From: [Kelly Bacon \(CD\)](#)
To: powellj@cwu.edu
Subject: BL-21-00026 Powell - Request for Information
Date: Friday, October 29, 2021 4:31:54 PM

In initial review of the above mentioned Boundary Line Adjustment application, the survey map is showing the parcel acreages as 14.6 and 23.8, before and after the BLA. The application is showing the following:

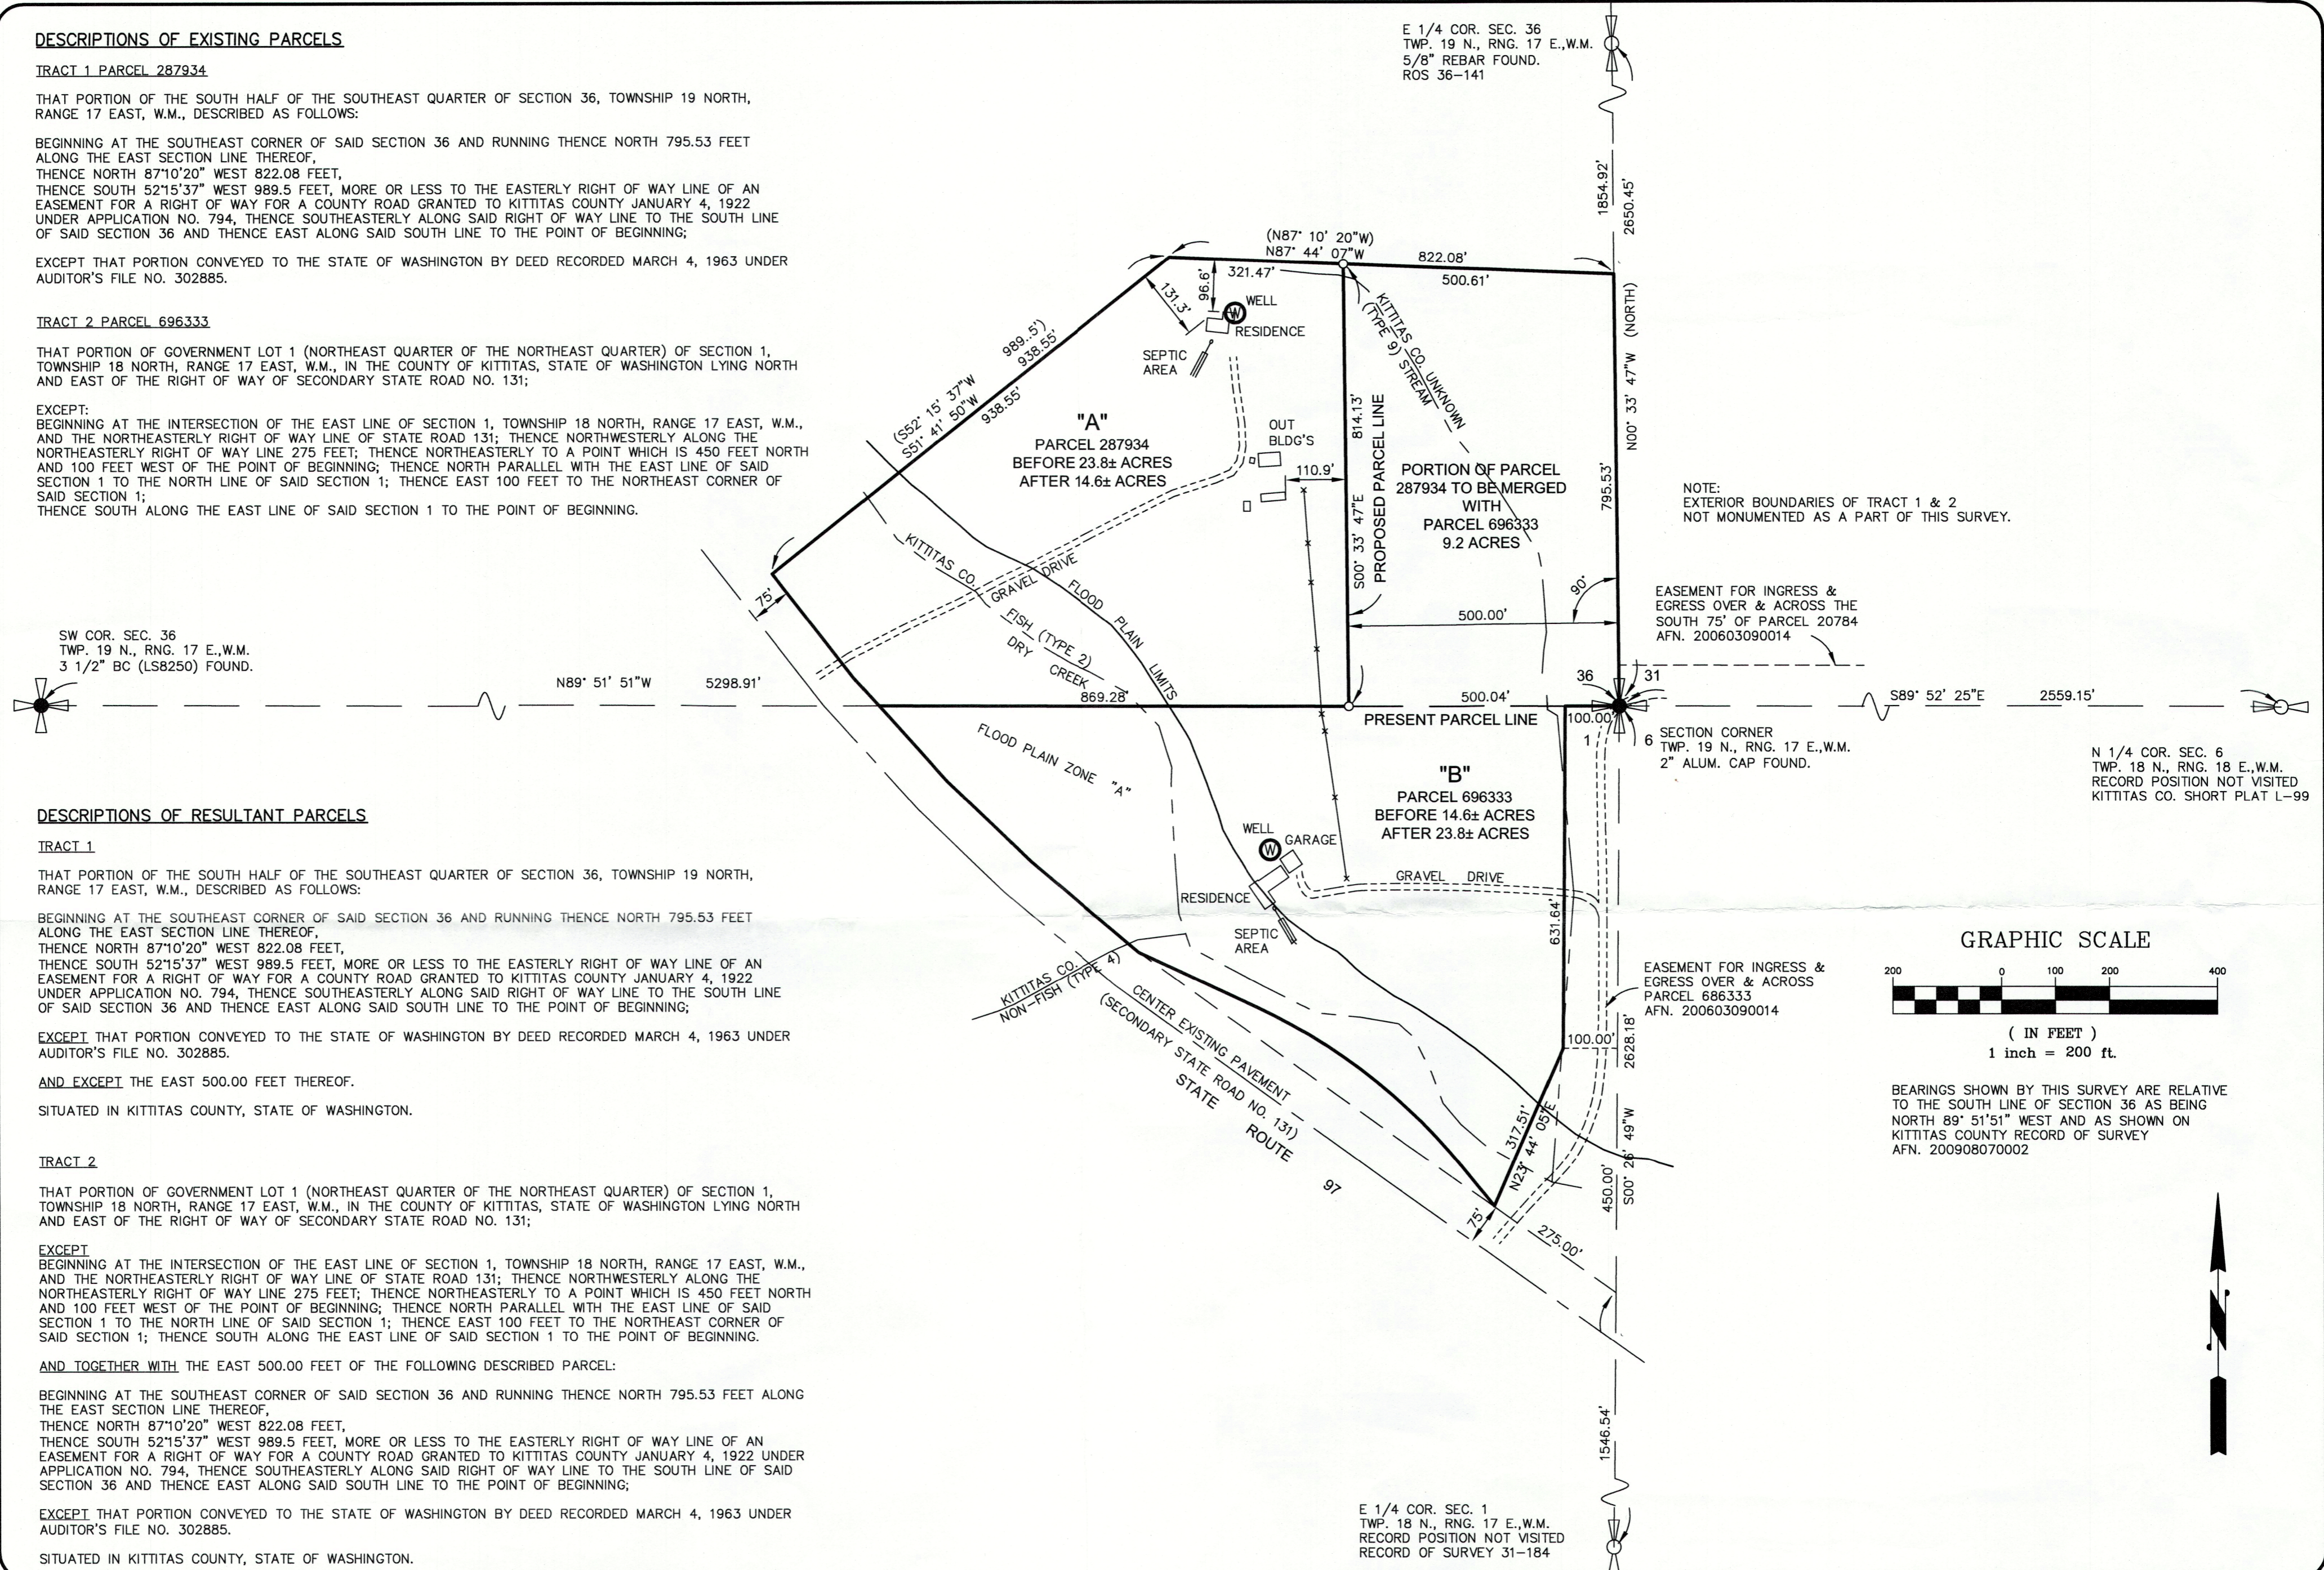
<u>Parcel</u>	<u>Before acreage</u>	<u>After acreage</u>
287934	23.8	14.1
696333	14.6	24.4

As these parcels are located within Agriculture 20 zoning, lot size minimums are 20 acres. During a BLA any non-conforming lot (14.6 acres) can not become any more non-conforming (14.1 acres).

If the application is incorrect on the lot sizes, please provide an updated sheet 2 and 3 of the application displaying the correct parcel sizes. Once I have received the updated information, I can proceed with processing your application.
